WEST SUSSEX COUNTY COUNCIL CONSULTATION

TO:	Arun District Council FAO: Andrew Wood
FROM:	Highways, WSCC
DATE:	04/01/2019
LOCATION:	Land Adjacent to Elm Lodge, Tamarisk Way, Ferring, West Sussex
SUBJECT:	FG/220/18/PL Erection 1 No. dwelling with integral garage
DATE OF SITE VISIT:	N/A
RECOMMENDATION:	☒ Advice ☐ Objection ☐ Modification ☐ No Objection ☐ More Information ☐ Refusal
S106 CONTRIBUTION TOTAL:	£N/A

PROPOSED GROUND FLOOR PLAN 1:50.

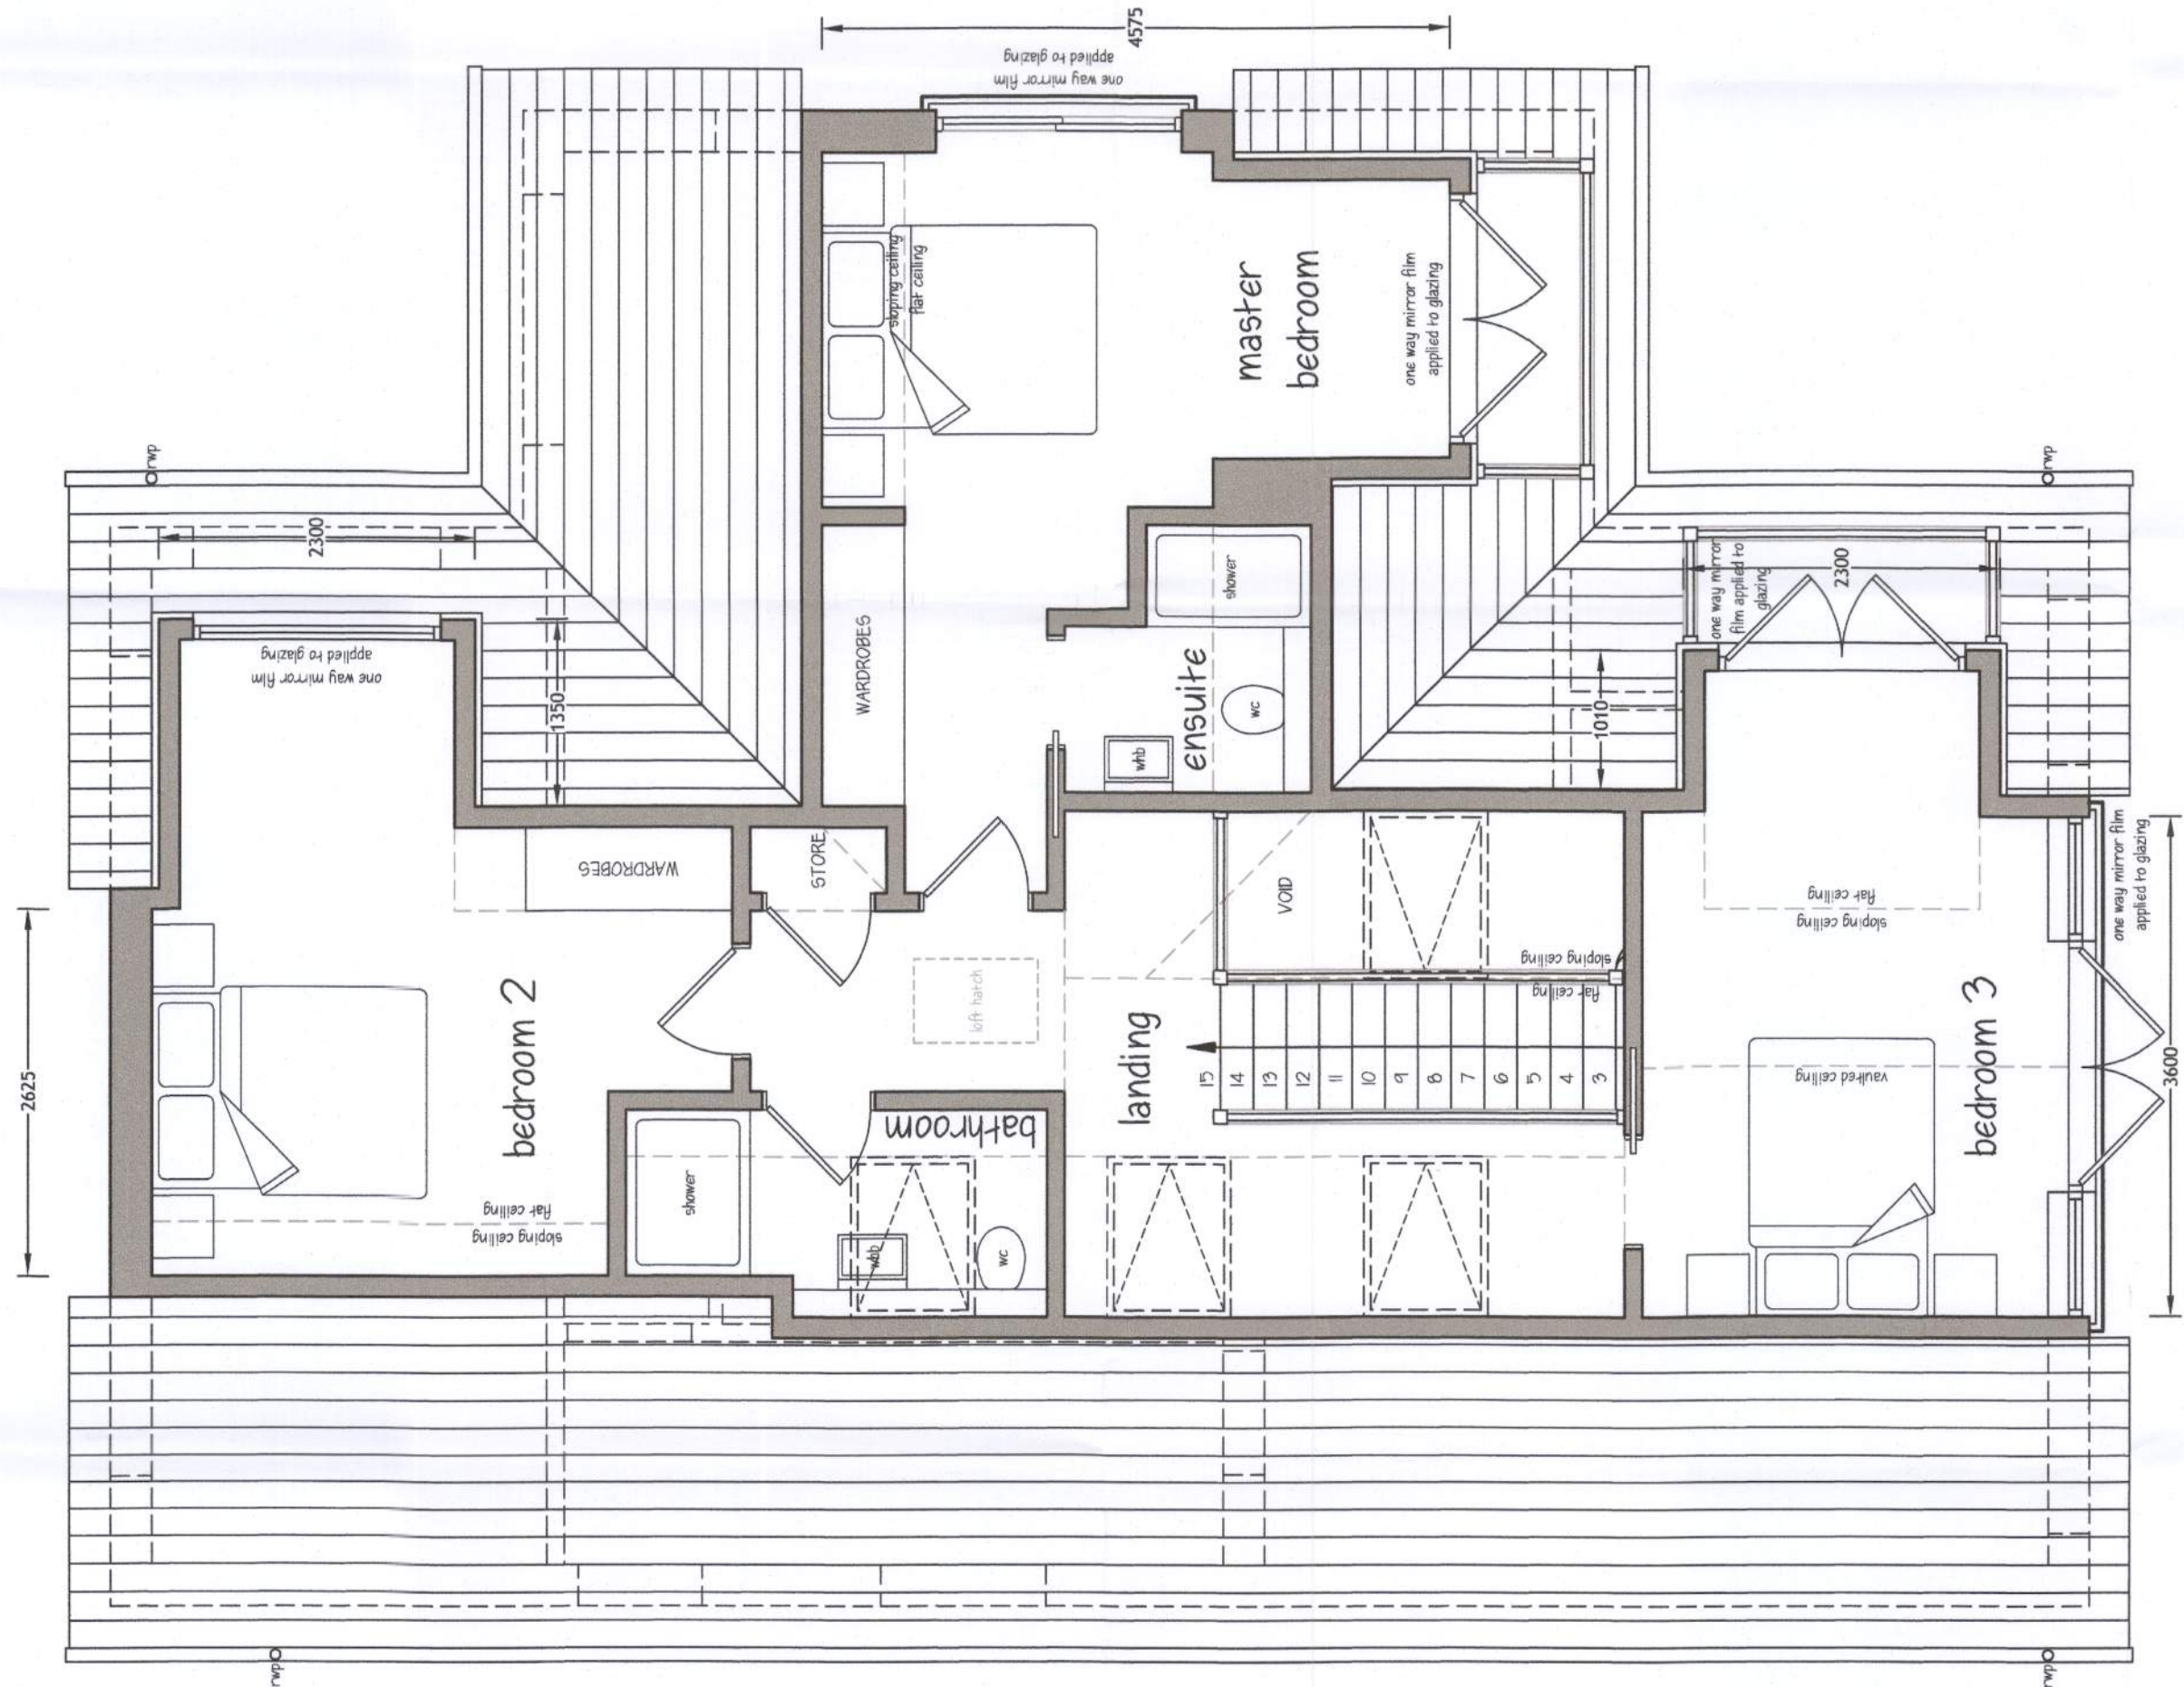
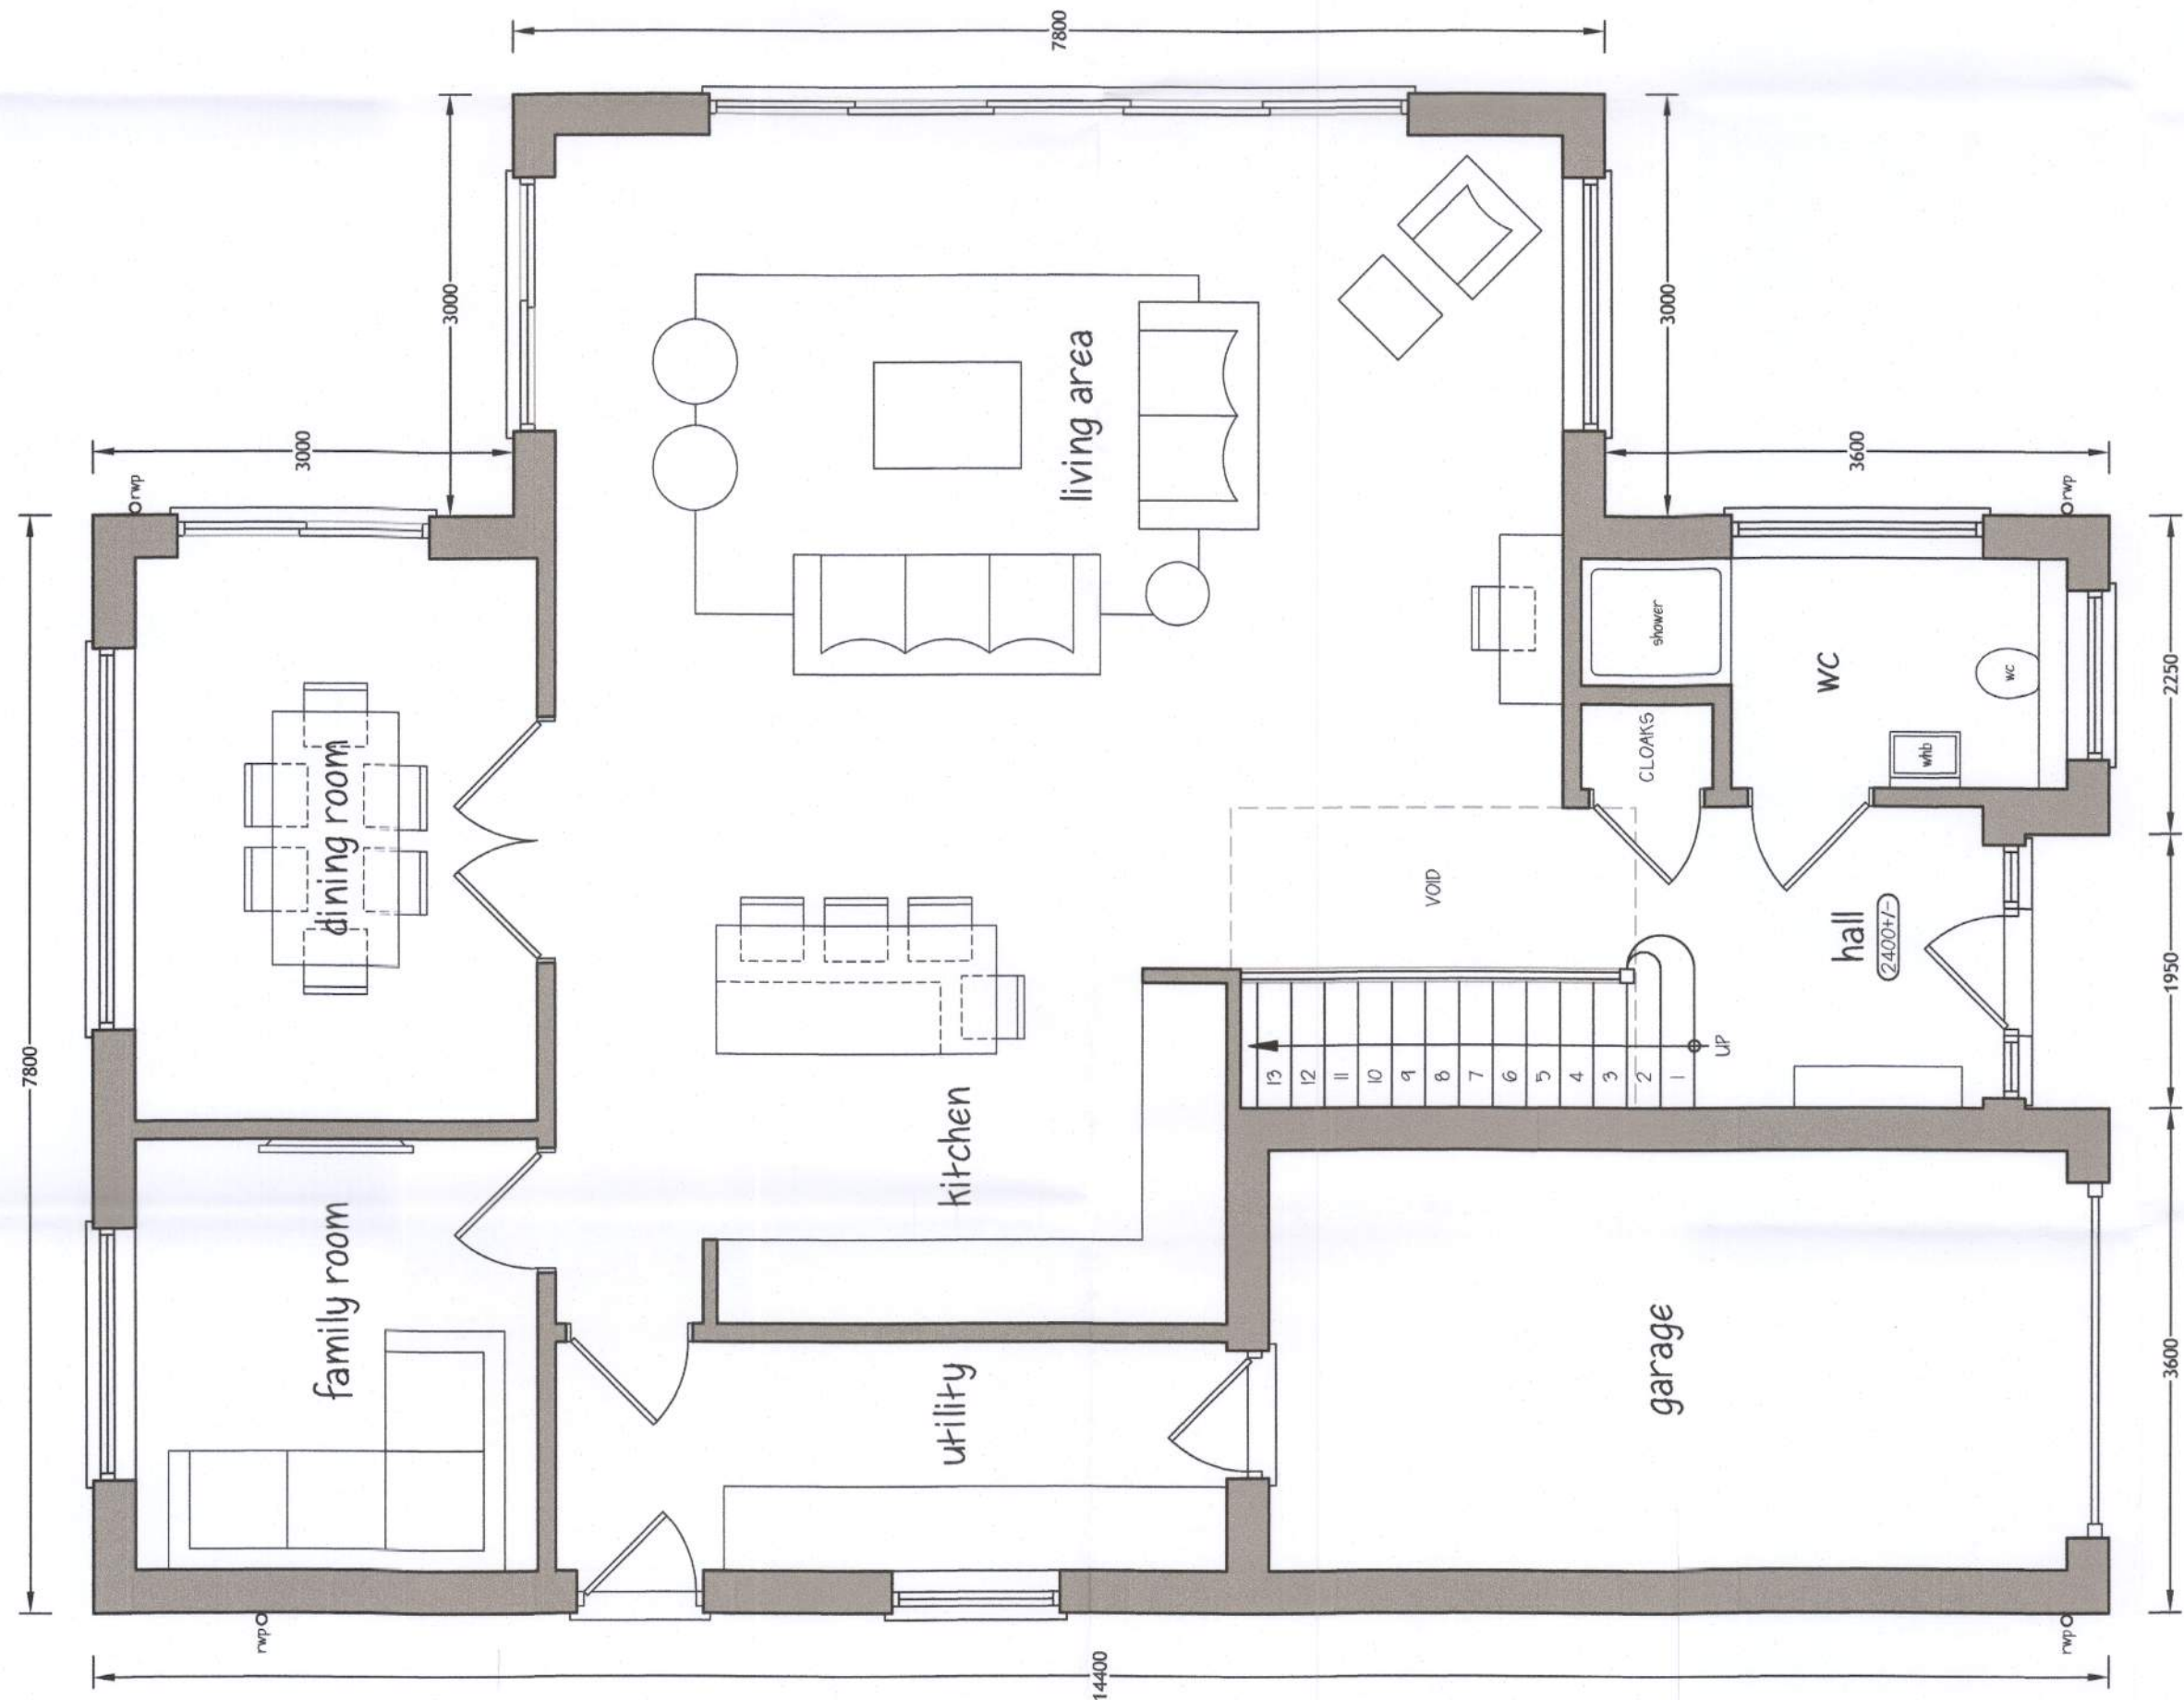
The proposed plans indicate that two off-street parking spaces will be provided for the proposed dwelling and an integral garage. The proposed plans demonstrate internal dimensions of 3 x 5.8m. In order to be counted towards parking provision for the dwelling, the minimum internal dimensions should meet Manual for Streets guidance of 3 x 6m. The applicant is advised to consider increasing the proposed garage depth to meet these minimum internal specifications. However, this is not anticipated to cause a highway safety concern in this location. This is anticipated to be sufficient parking provision for a dwelling of this size and location. A turn on site would be preferred however there is clearly insufficient space on site to accommodate this. However, neighbouring properties have similar arrangements and operate without evidence of safety concern.
